PlaceChangers Ltd

# Conversion of Ebenezer Methodist Chapel

Proposed Ground Floor Plan

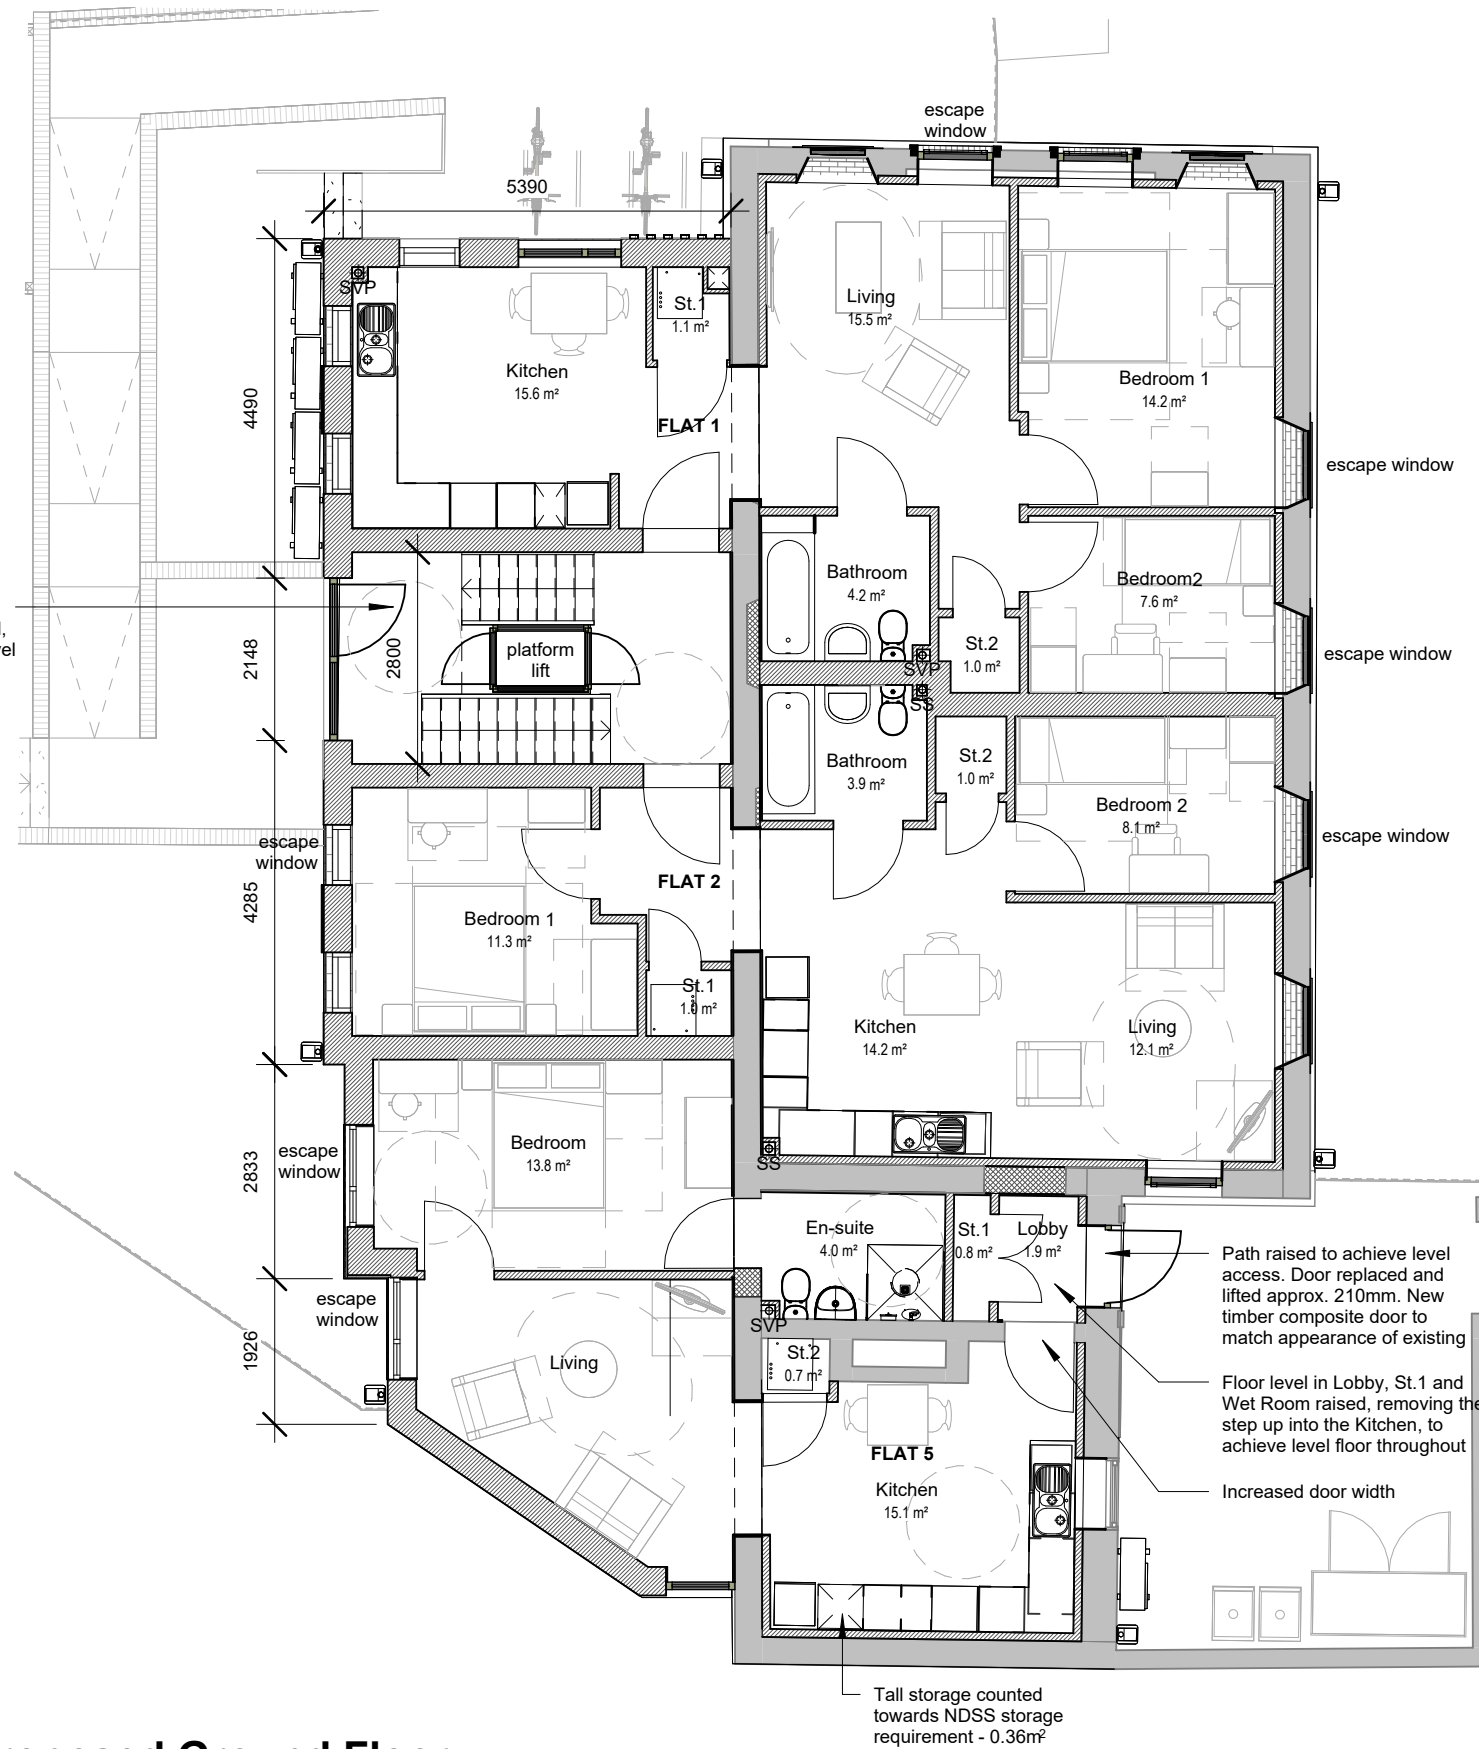
Personally,I think it looks awful,an old building with too many modern day attachments. I also have to take umbrage with the fact you have only 1 designated flat for a wheelchair user,and that has only 1 bedroom – believe it or not,wheelchair users are capable of having families,may have a career who lives in etc.Prudhoe PCP partnership and Karbon,still in the dark ages

**Good idea:** Suggest a 2nd bedroom for the disabled access unit. Good idea in principle and views look to hold character of the building, whilst adding extra space. Parking provision is a must for development, whilst low maintenance garden area will help blend the new west elevation to the existing lawned surroundings.

# Proposed Site Plan

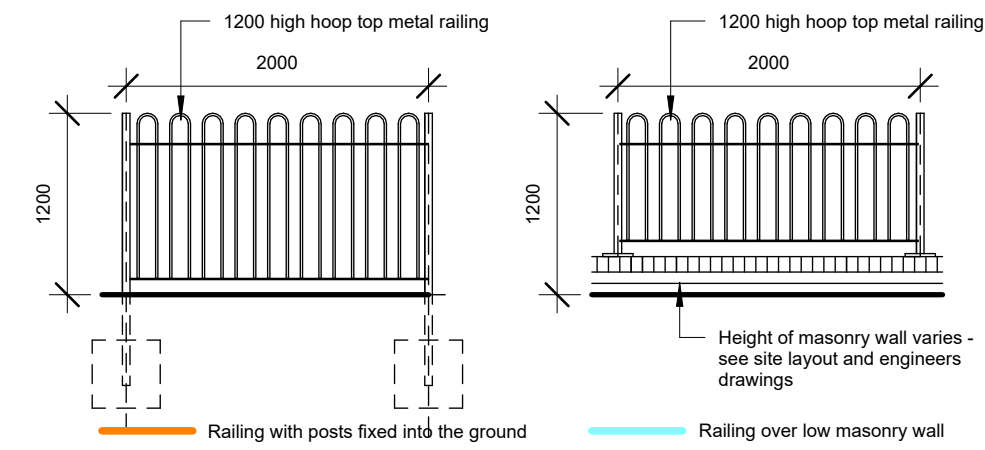
The flats would increase the volume of traffic on scales crescent which is already overcrowded with parked cars .parking layby along scales crescent would help

**Good idea:** I like the proposed planting but I feel this could be extended to include some blossom trees perhaps. Green space is important

Seems a lot of parking spaces for flats so near a bus route

**Needs improving:** It's a lot of parking places when we should be discouraging car use. One per flat should be enough. Cycle storage and charge points would be a good idea.

**Good idea:** Like the planting and green space. The more the better :-). Consider low maintenance trees. Is there an area for flat residents to garden if they wanted to?
